Application Ref:	3/2025/0785			 Ribble Valley Borough Council <small>www.ribblevalley.gov.uk</small>				
Date Inspected:	11/11/25	Site Notice:	11/11/25					
Officer:	LW							
DELEGATED ITEM FILE REPORT:					APPROVAL

Development Description:	Demolition of existing front and rear porch. Proposed construction of two-storey front extension, rear balcony, replacement front and rear porch, new chimney and fenestration alterations including alterations to front bay window.
Site Address/Location:	Meadow View Croft, Dinkling Green Lane, Leagram, PR3 2QS.

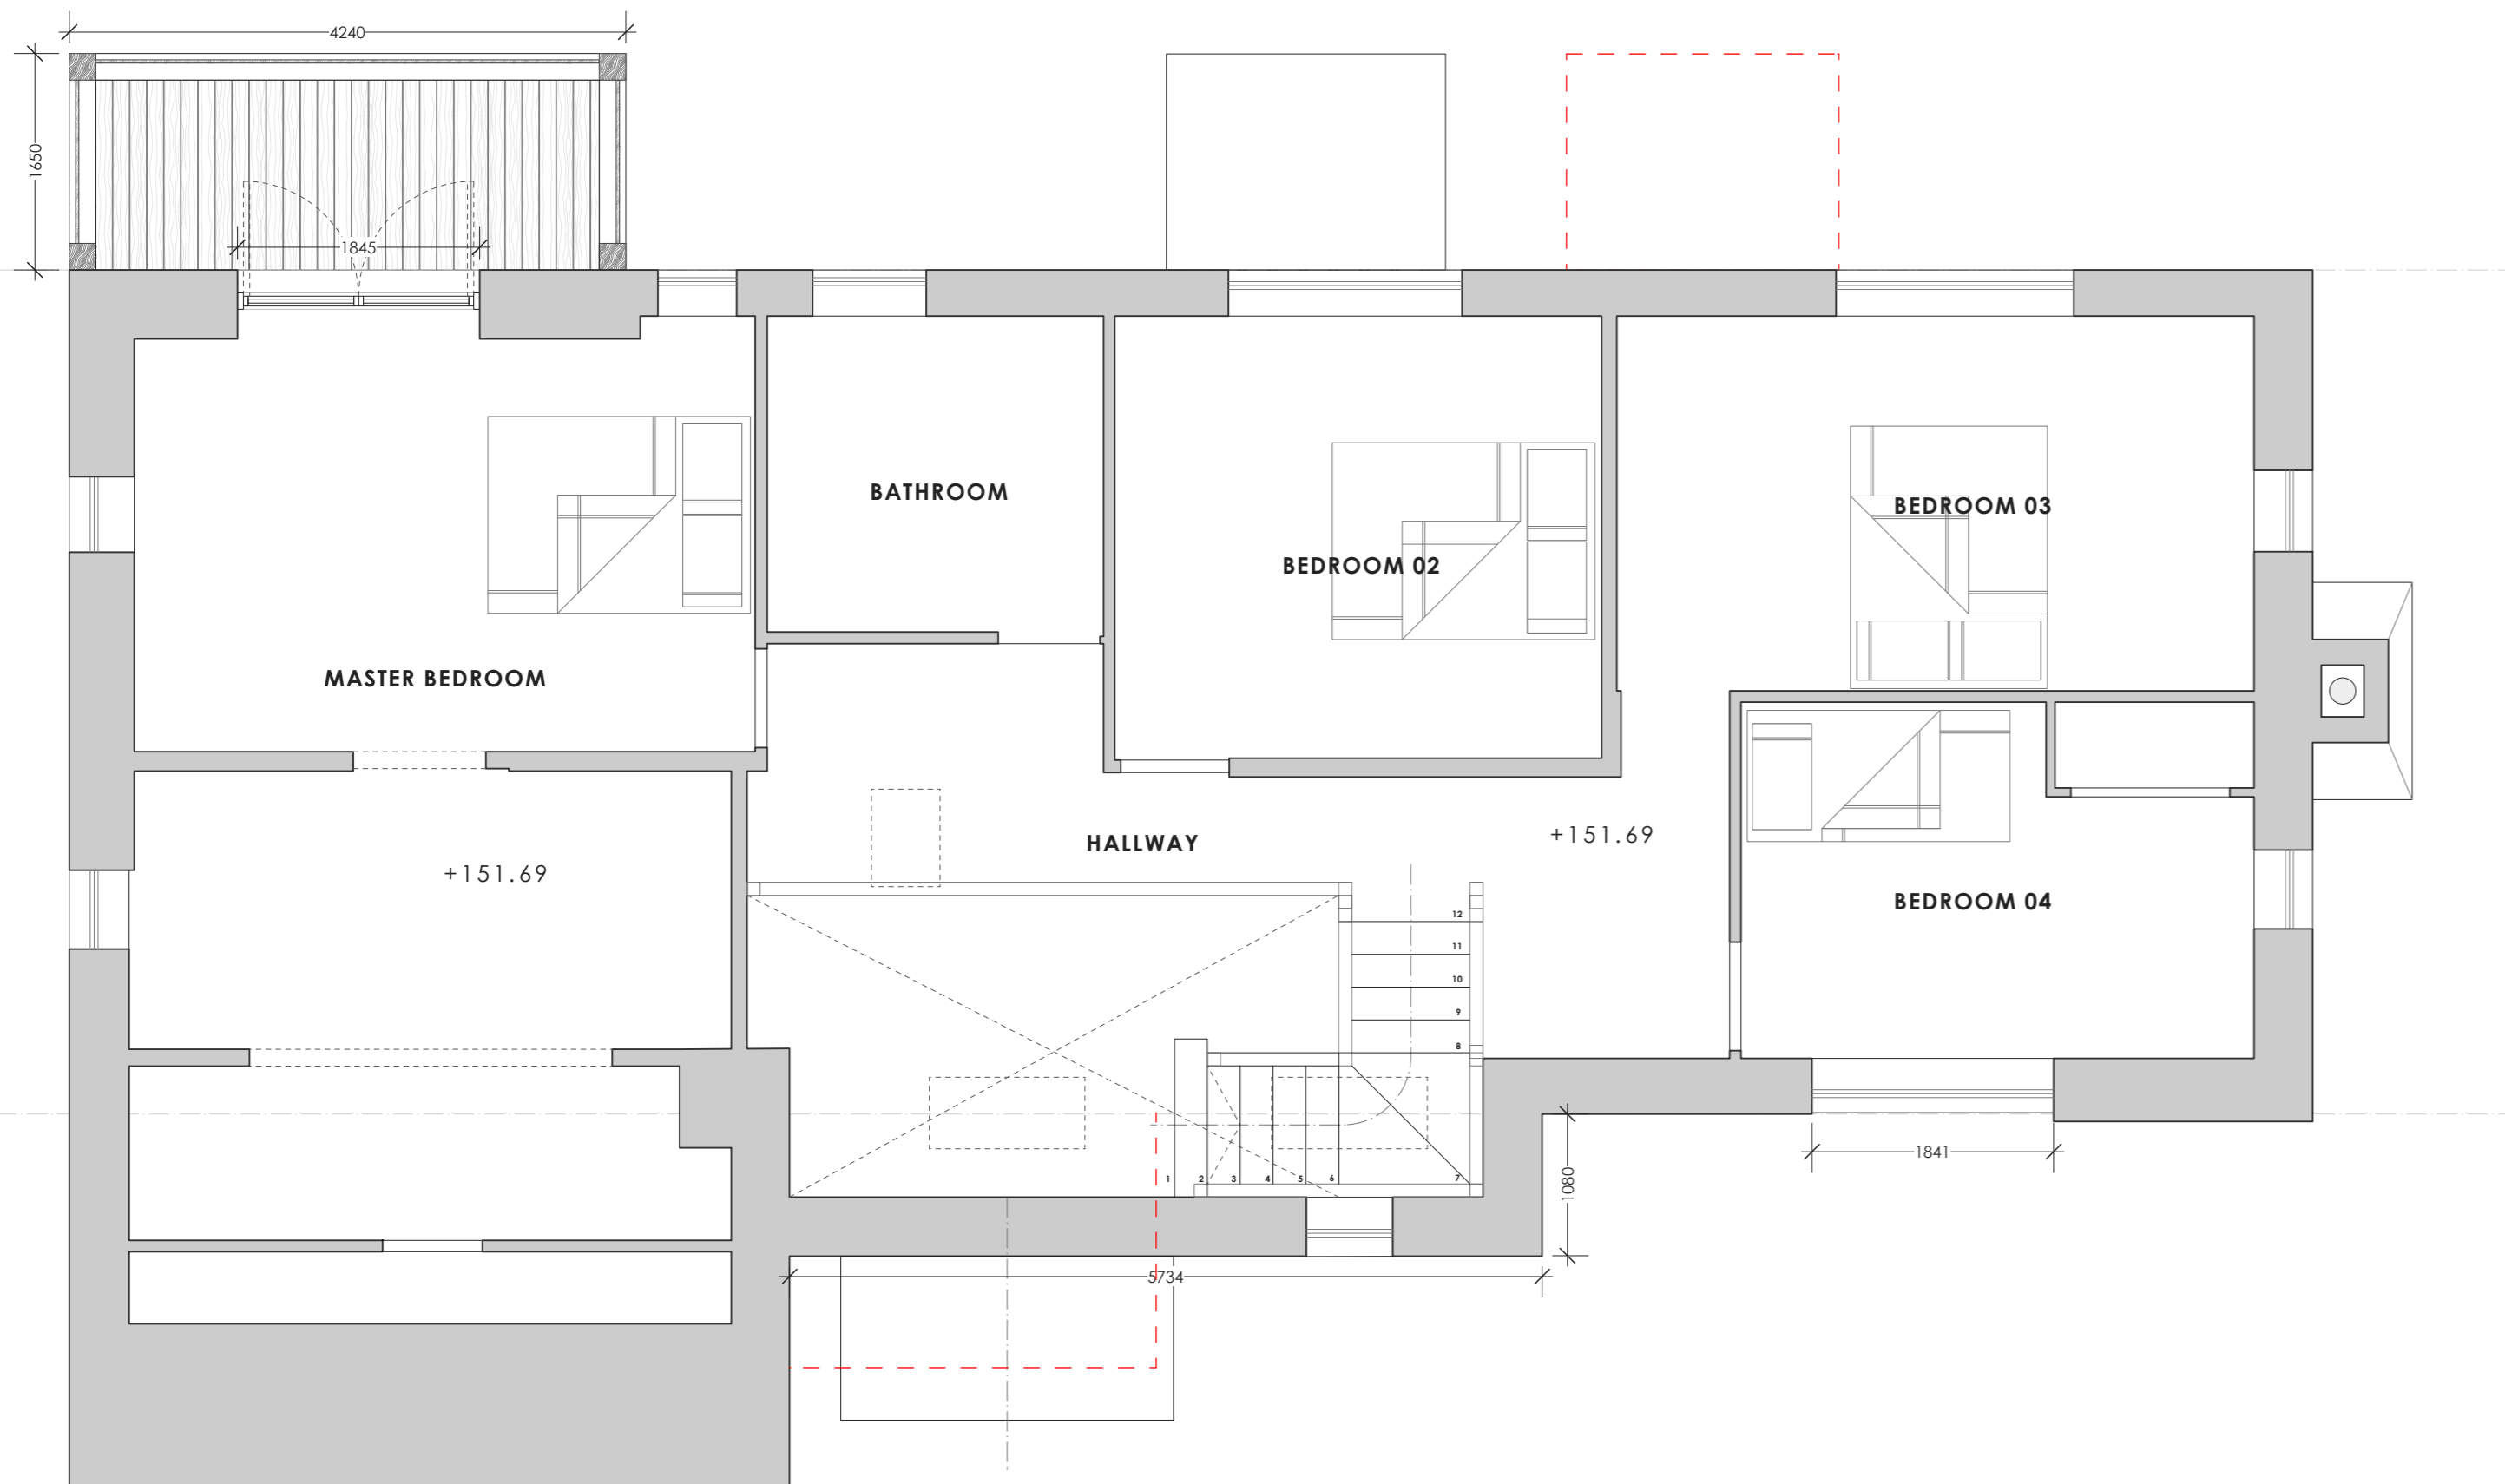
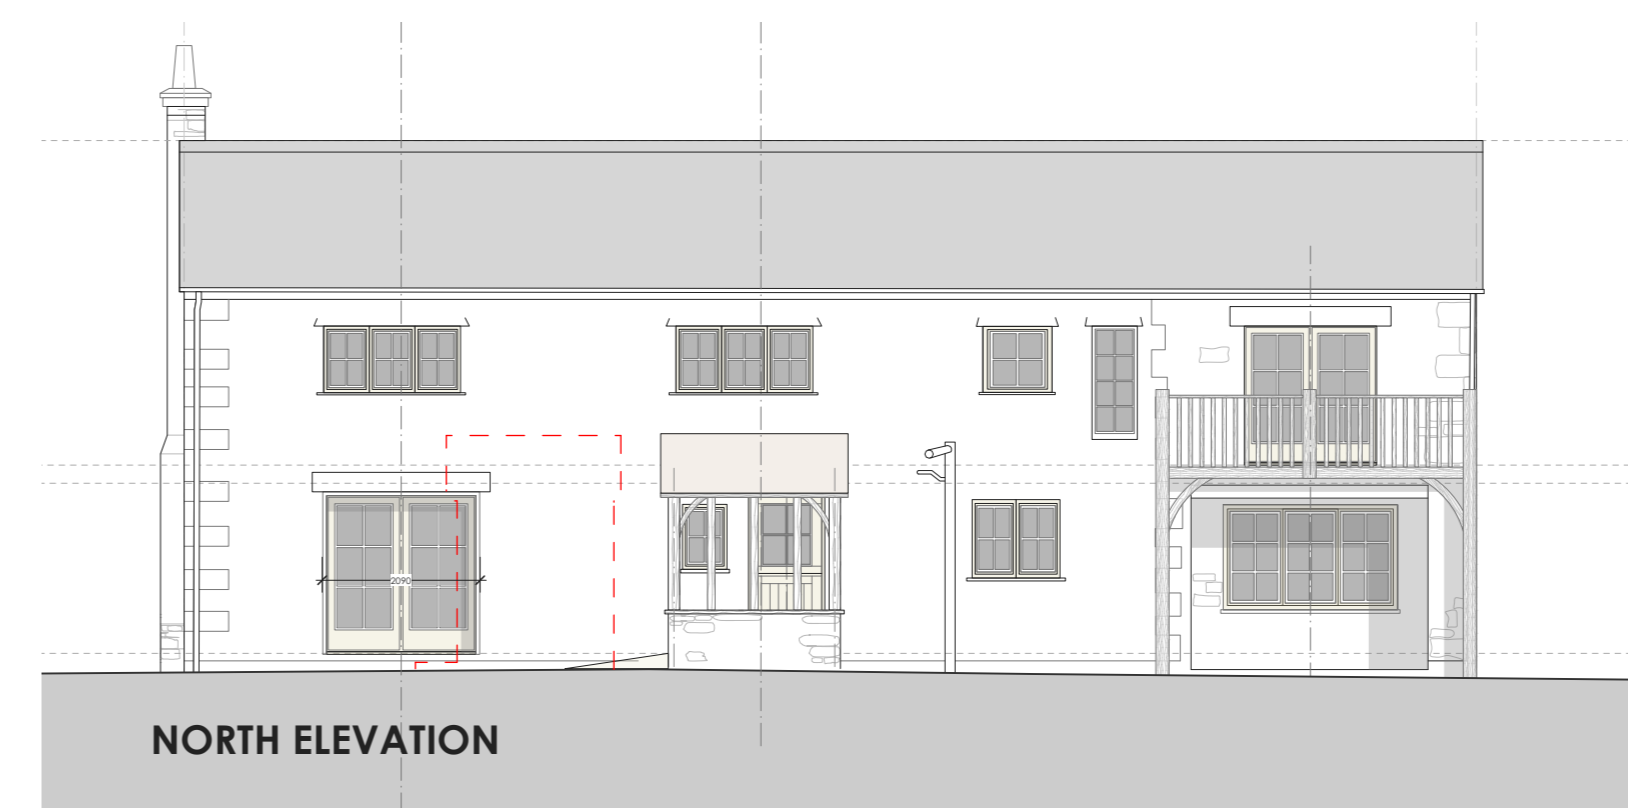
The proposed stone based two storey front extension would project 1m from the principal elevation of the application property with a width of 5.7m. A lean-to slate roof would be incorporated measuring 3.9m to the eaves and 4.9m to the ridge, with 2no. rooflights also included. To the front elevation an access door and 1no. window opening would be featured.

The proposed oak framed front porch with low stone walls would project a further 1m from the proposed front extension with a width of 2.5m to create a covered entrance over the access door. The addition would feature a dual pitched slate roof with an eaves and ridge height of 2.6m and 3.4m respectively.

The proposed rear porch would have a footprint of 2.1m by 1.6m and would feature a slate lean-to roof measuring 2.3m to the eaves and 3m to the ridge.

The proposed oak framed balcony would measure 1.7m by 4.2m with a height of 2.8m. Access onto the balcony is to be via a set of glazed double doors from the master bedroom and a 1m high oak balustrade would be included.

As part of the overall development, a new chimney would also be constructed to the eastern facing elevation with a maximum height of 8.3m. The existing bay window to the principal elevation of the dwelling would also be re-built, while replacement windows would be incorporated throughout. To the western side elevation an existing ground floor window would be replaced by glazed double doors and 1no. additional ground floor window would be created. Another ground floor window to the rear elevation would also be replaced with double doors.

The proposed two-storey front extension would result in a relatively modest addition to the existing built form of the application property, projecting 1m from the principal elevation of the dwellinghouse with a maximum height of 4.9m to tie in with the roof pitch of the main dwellinghouse. The proposal would therefore remain sympathetic to the existing property and would not result in any measurable undue harm upon the existing visual amenities of the immediate or wider locality. The proposed front porch is also considered acceptable insofar that it would replace an existing front porch and its overall size, scale and design would appear relatively modest when viewed in context with the main dwellinghouse.

The proposed balcony and porch to the rear of the property would not be afforded a high level of visibility from the public realm and therefore any impact upon the surrounding landscape would be limited. Notwithstanding this, the proposed additions do not raise any concerns with respect to the visual amenity or external appearance. The proposed porch would replace an existing rear porch which is proposed for demolition, albeit in a slightly different location, and the development would remain subordinate and in keeping with the parent building. Furthermore, it is not considered that the proposed chimney or fenestration alterations would result in any significant detrimental harm to the property with its traditional rural character to be largely retained.

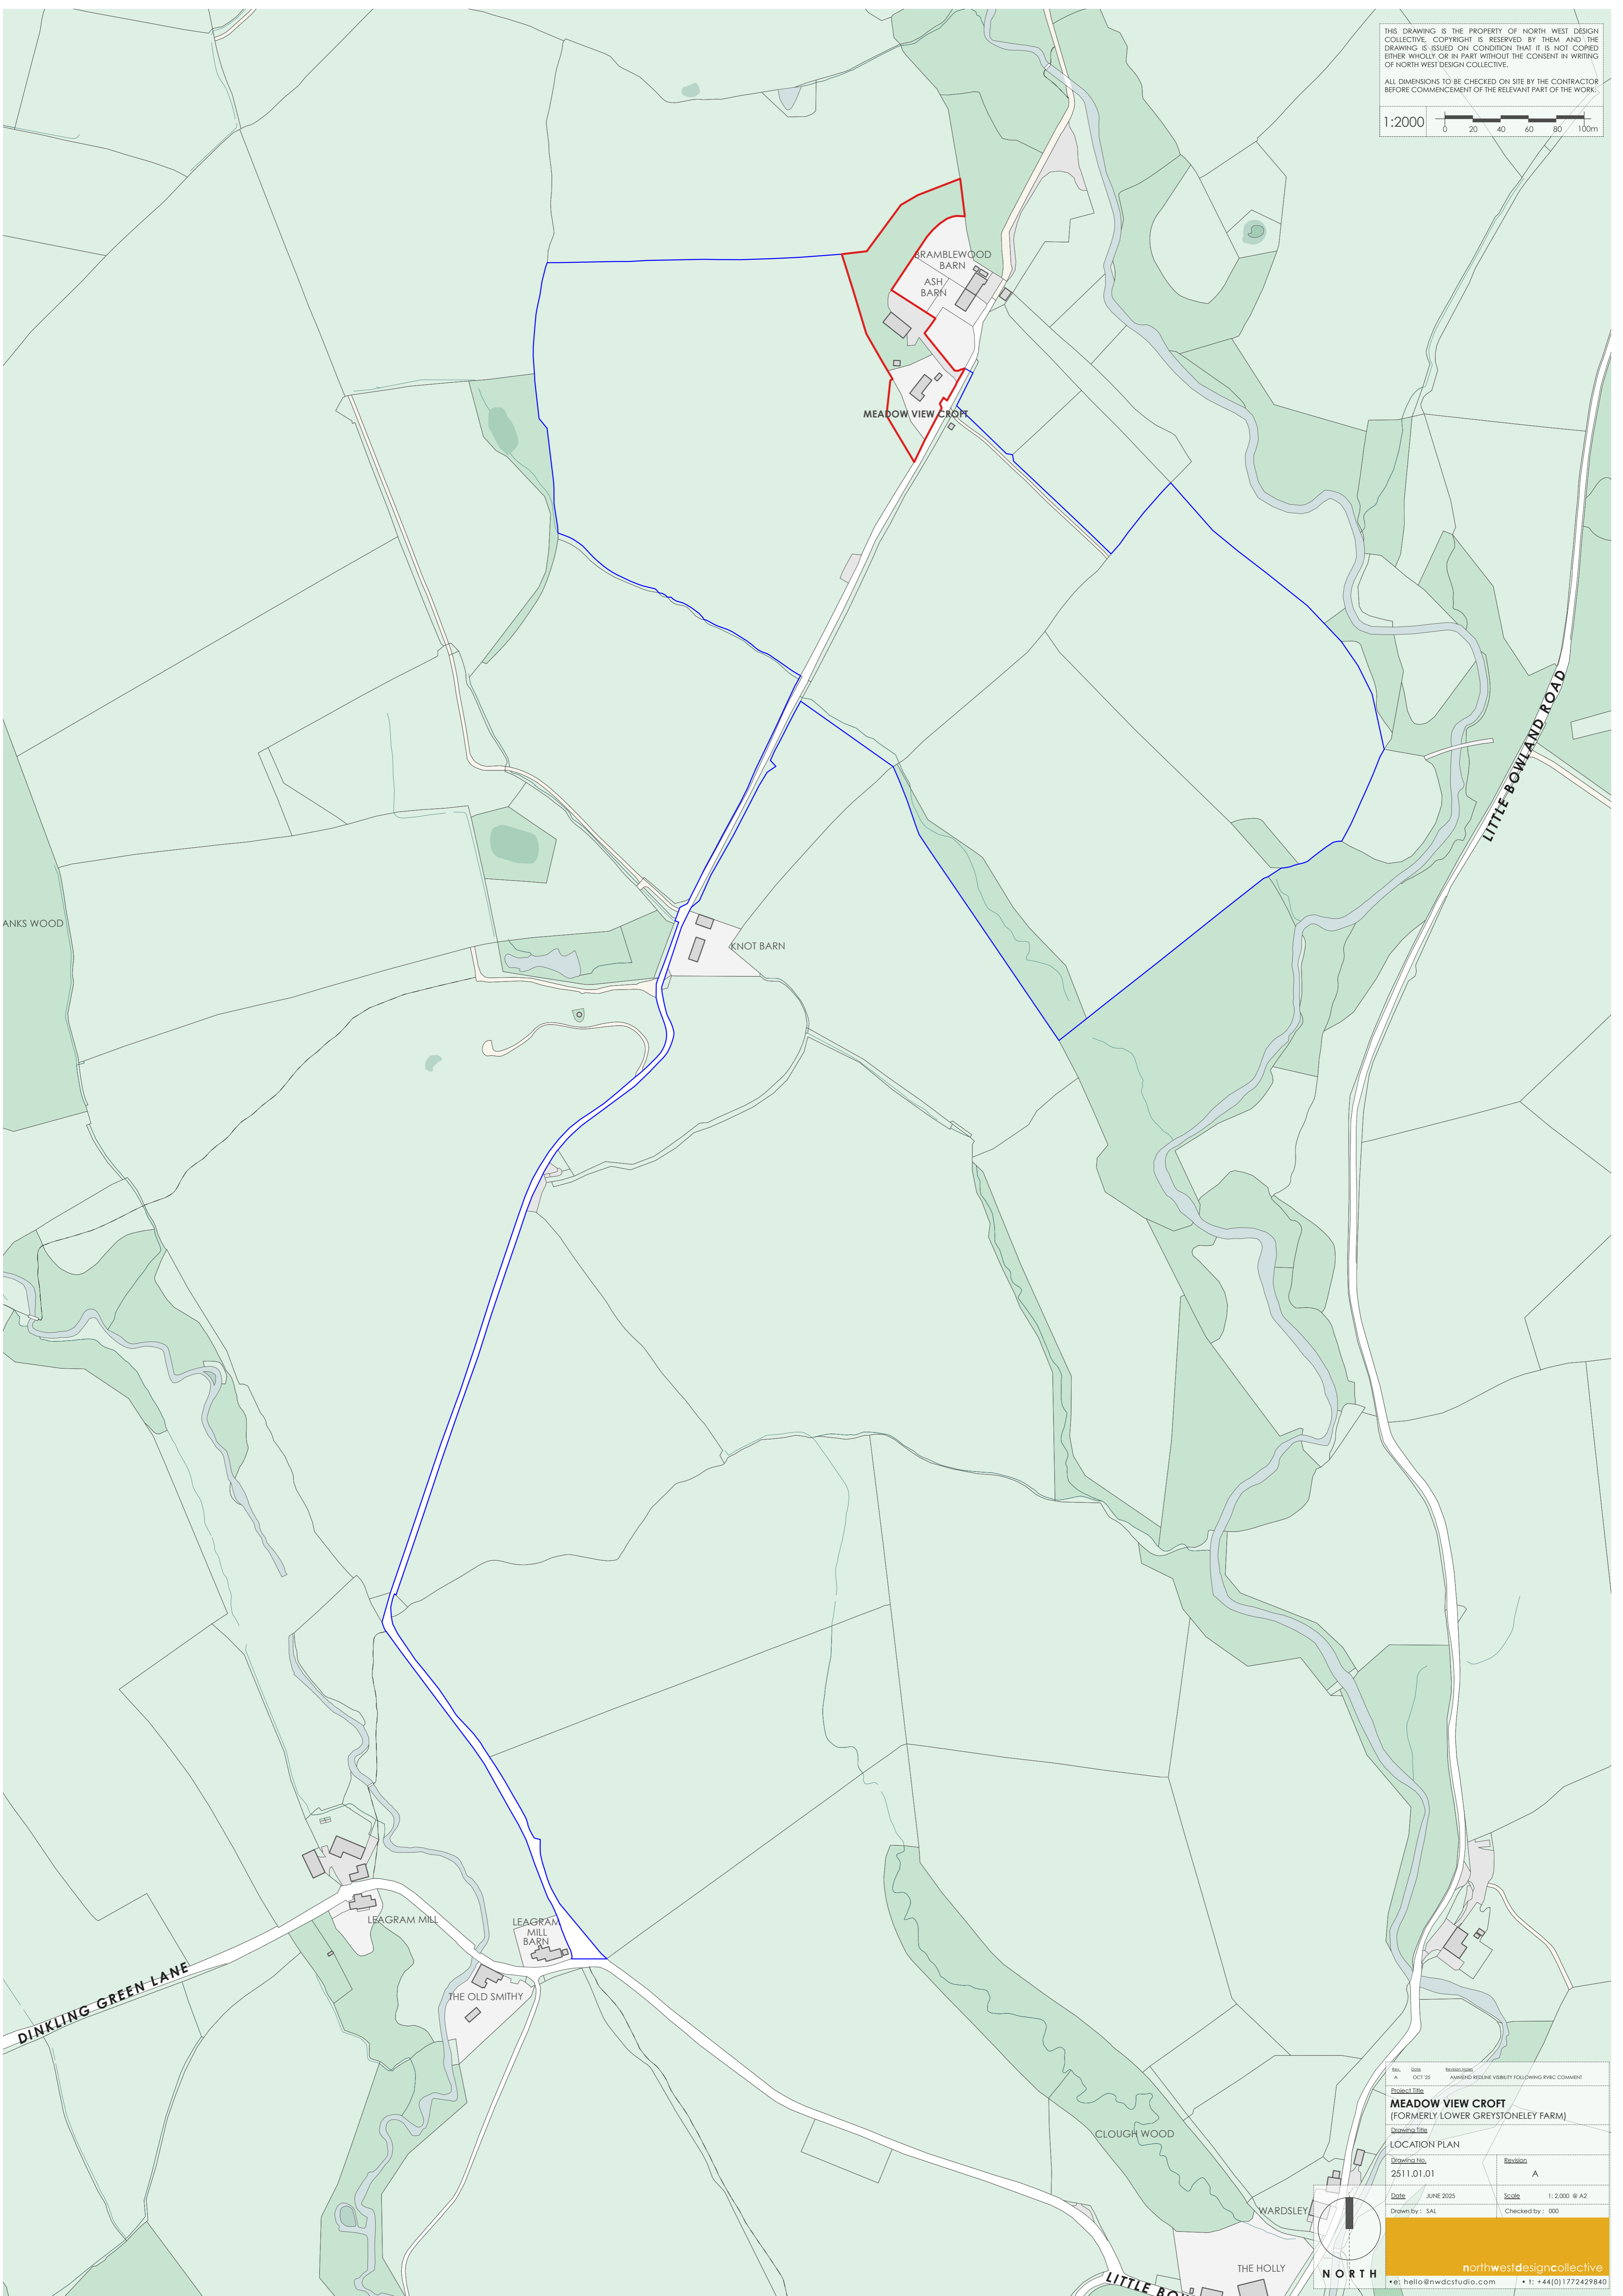
It is noted that the red edge boundary shown on the submitted Location Plan (dwg no. 2511.01.01 Rev A) includes land which does not form part of the lawful curtilage of the application property, as denoted by the red edge boundary approved under application 3/1982/0543 which granted outline planning consent for the original dwelling. However, the proposed development would be contained well within the lawful curtilage of the dwellinghouse and therefore it is not considered necessary to request the submission of an amended red edge as part of the determination of this application.
